Gatwick Northern Runway TR020005

PRINCIPAL AREAS OF DISAGREEMENT SUMMARY STATEMENT – DEADLINE 2 UPDATE

March 2024

Project Code-Location-Discipline-Volume-Type-Unique Number
41700- XX -B -LLO - GA - 200175

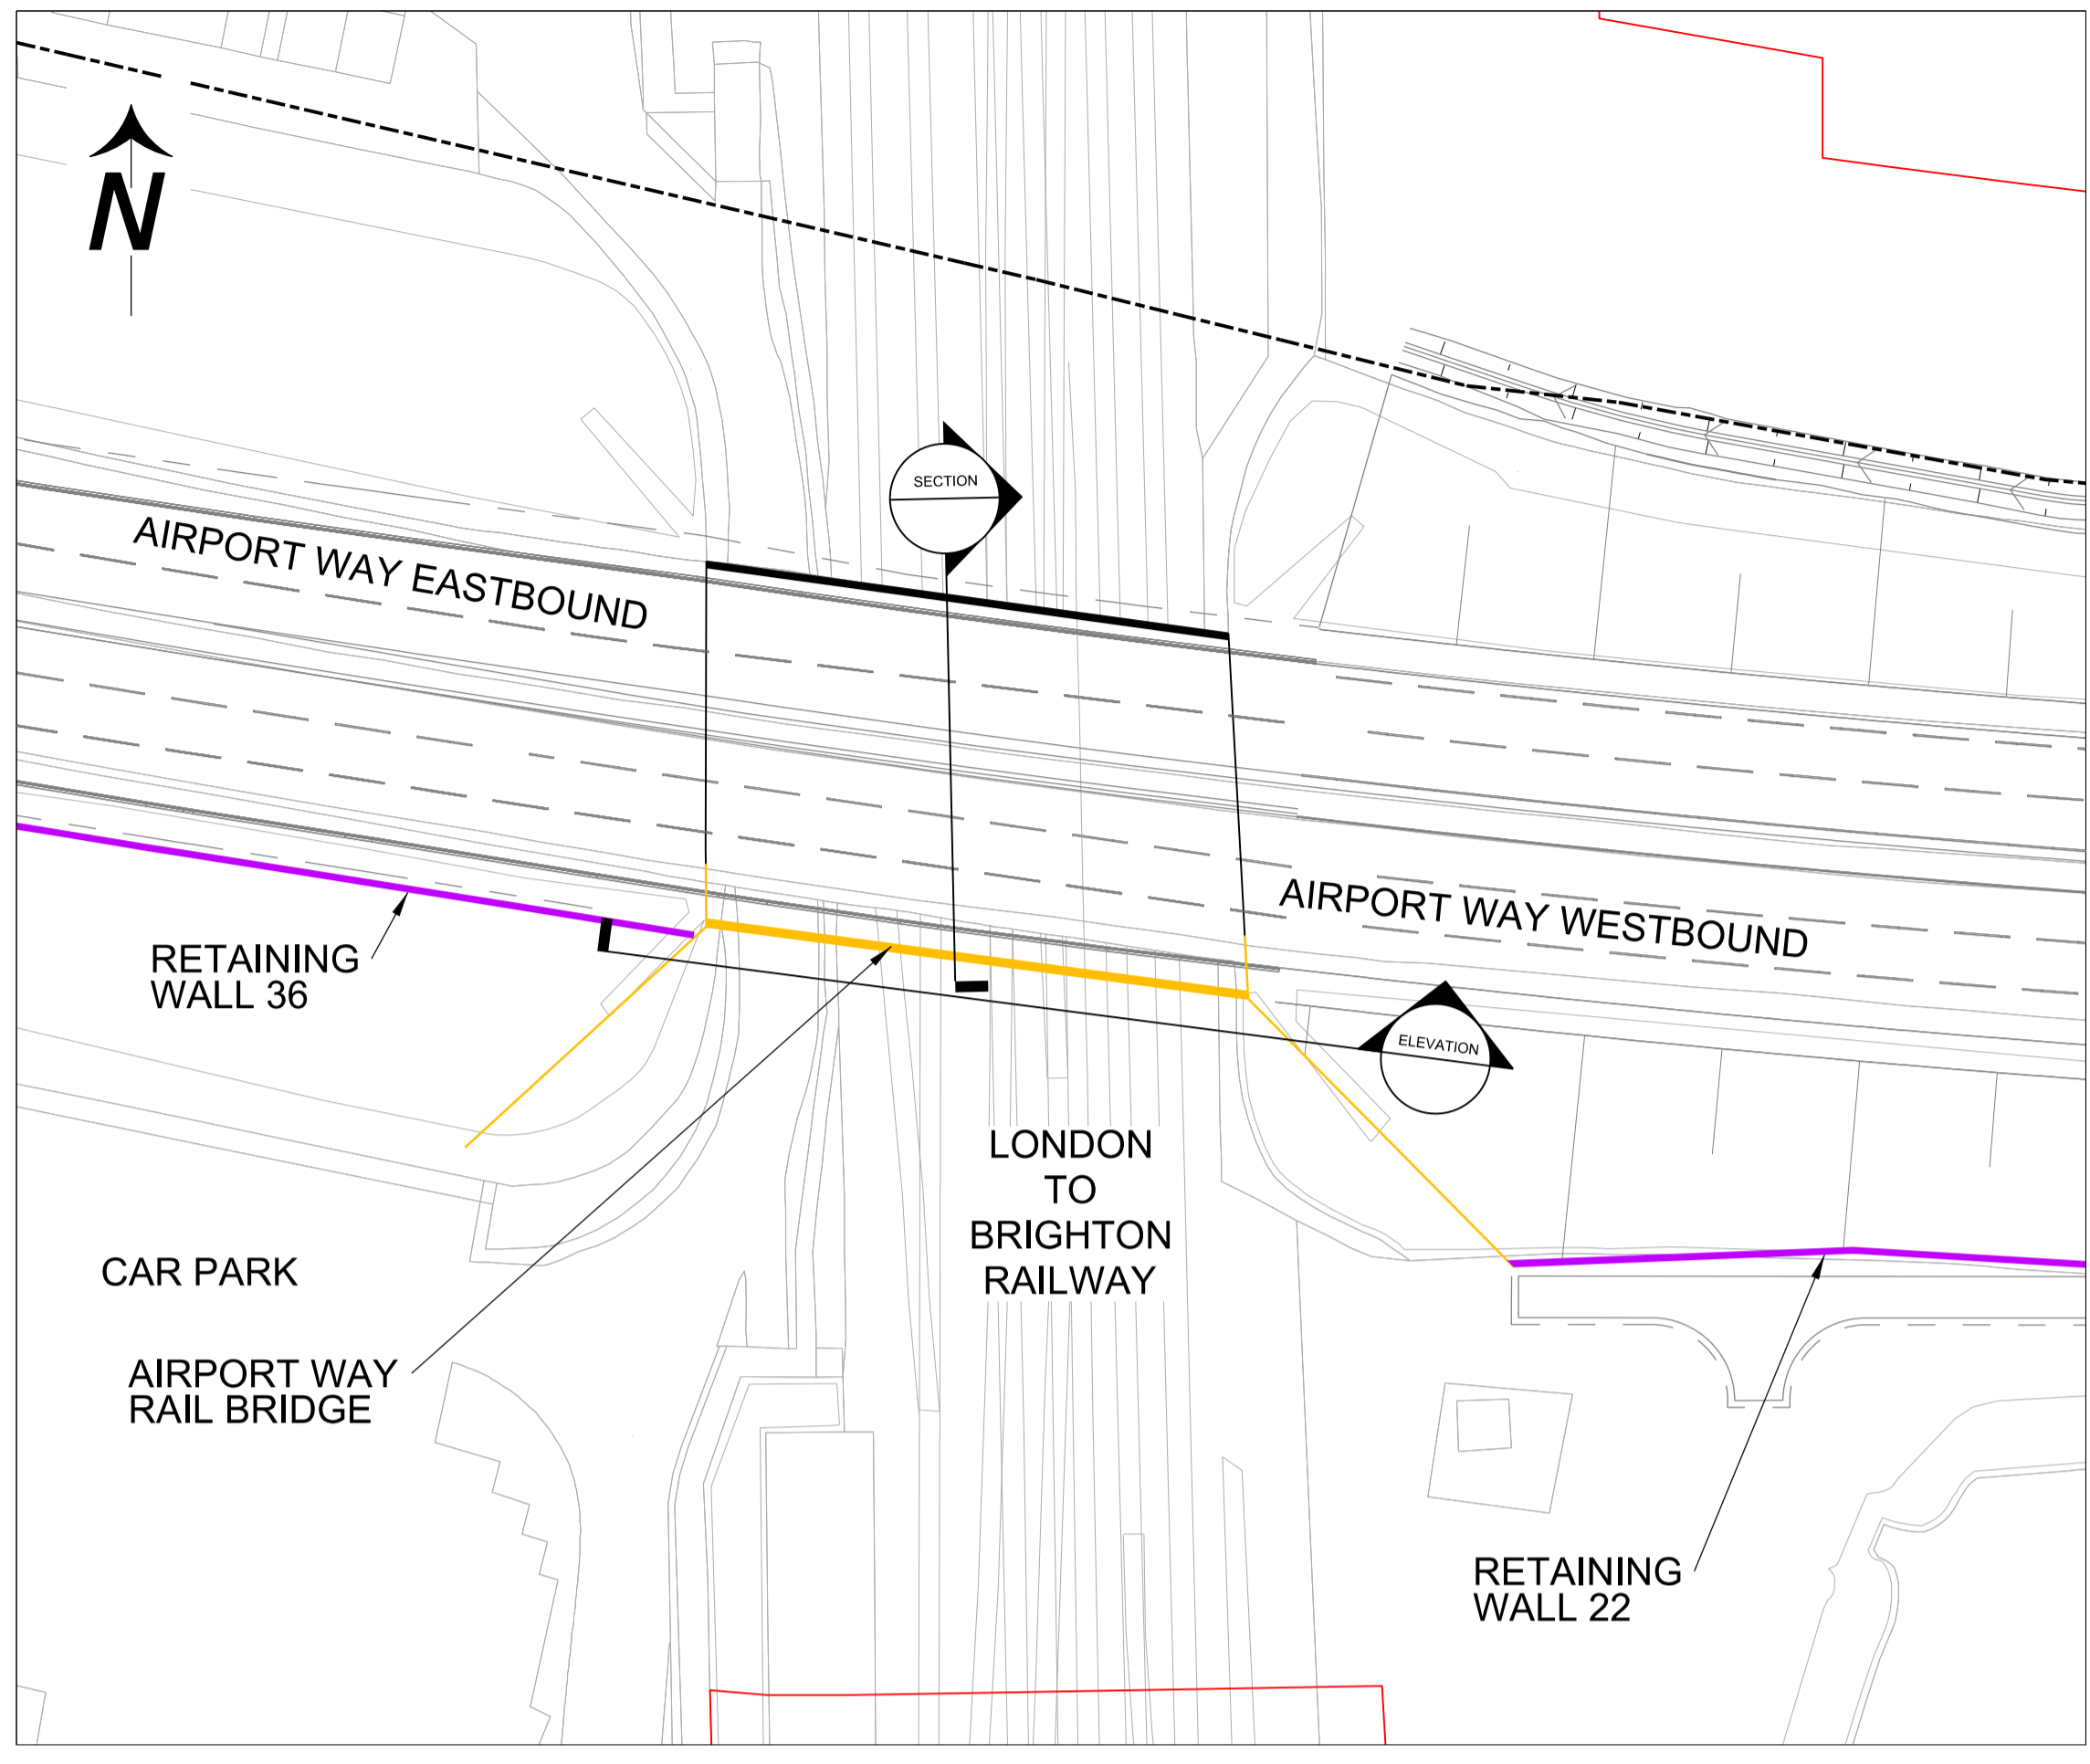
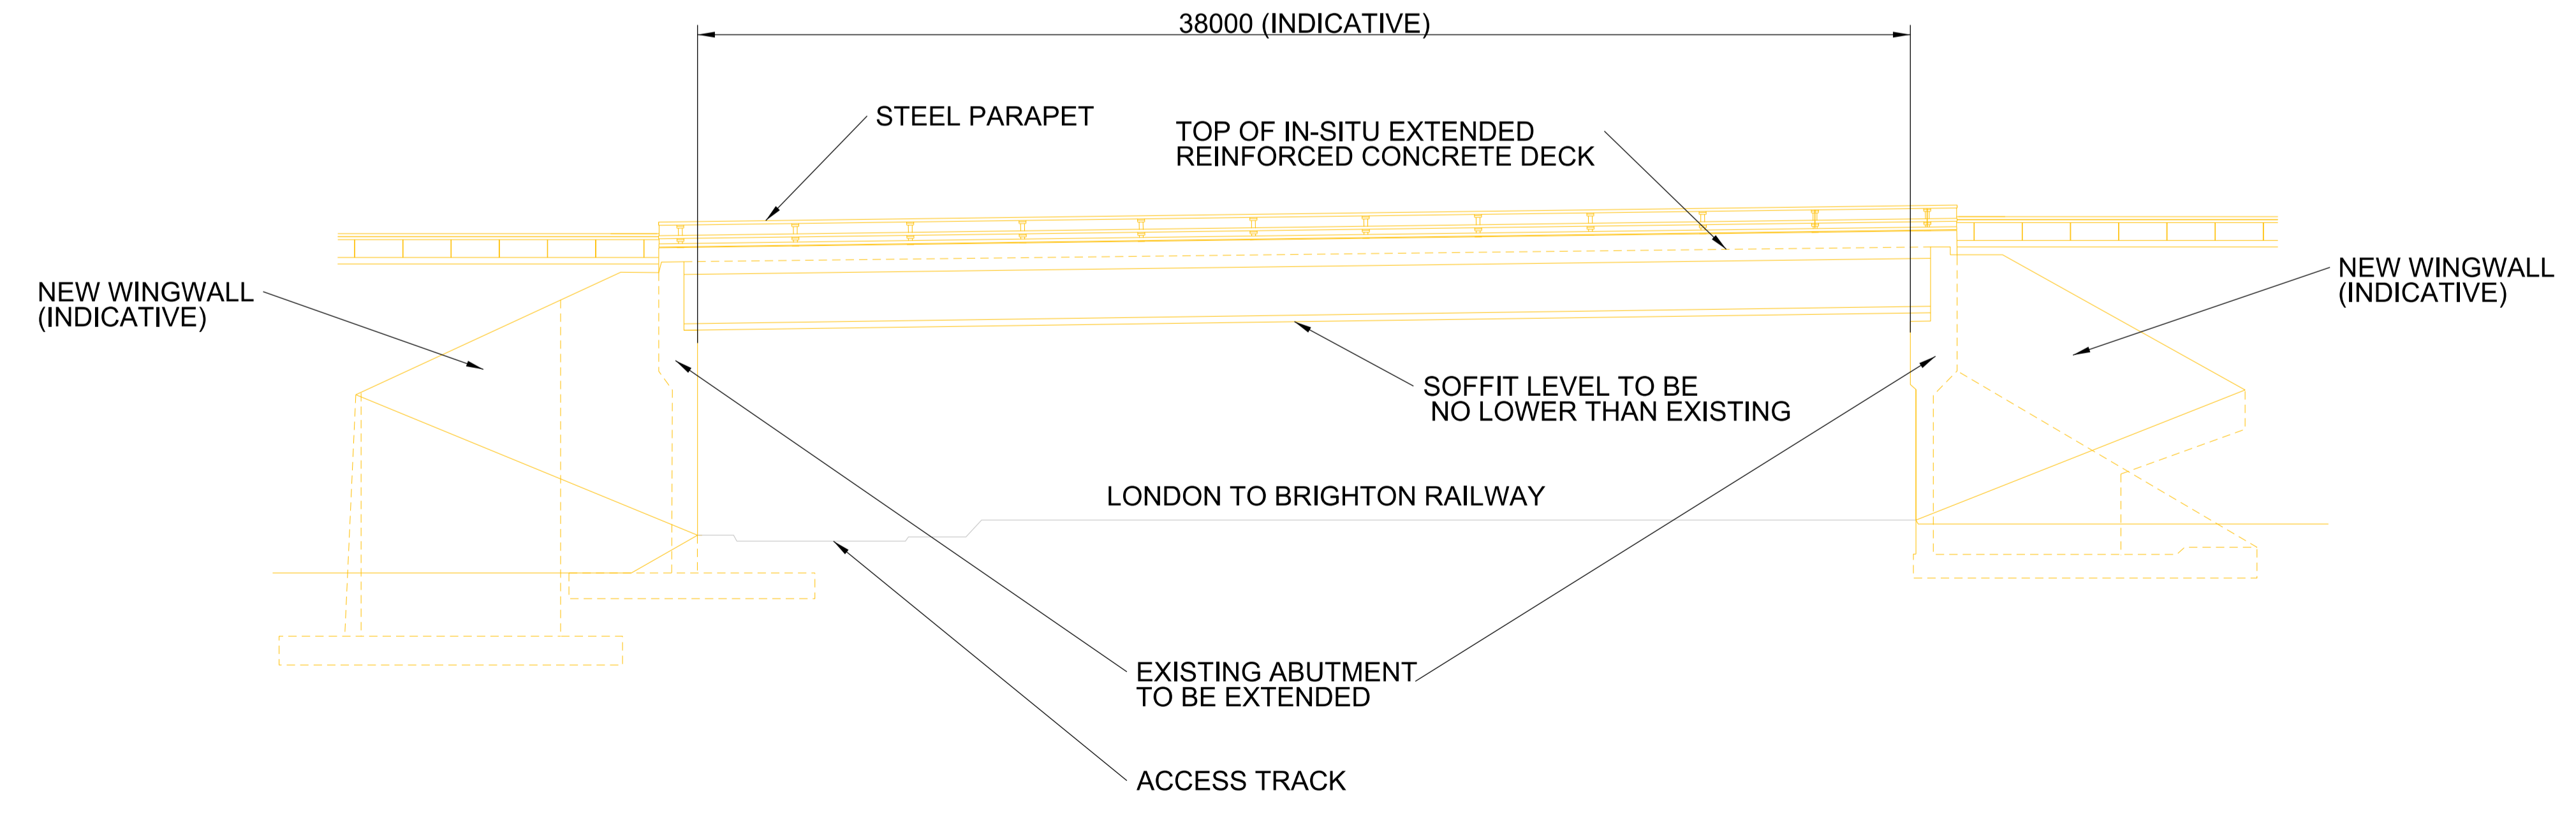
37 2.20.5.7	Structure Section Drawings (TR020005/APP/022) Drawing 41700-XX-B-LLO-GA-200175	This drawing provides a section; however, the section does not indicate there being any structural parapet on the north side of the noise barrier.	<p>The Applicant is to confirm whether there is edge restraint being provided on this area and, if required, ensure that this drawing is updated.</p> <p>Updated position (Deadline 2): National Highways has reviewed the proposals by the Applicant and recommends the Applicant considers the following two options:</p> <p>If maintenance activities require operatives to access to the rear of the noise barrier, a pedestrian parapet system is to be installed on the structure to act as an edge restraint to minimise the risk of falling.</p> <p>If there are no maintenance activities required to the rear of the noise barrier, the noise barrier is to be repositioned on the structure to sit on the plinth, thereby restricting any unauthorised access to the structure. If this solution is considered by the Applicant, the relocation of the noise barrier may need to be considered as part of any acoustic assessments.</p>	High
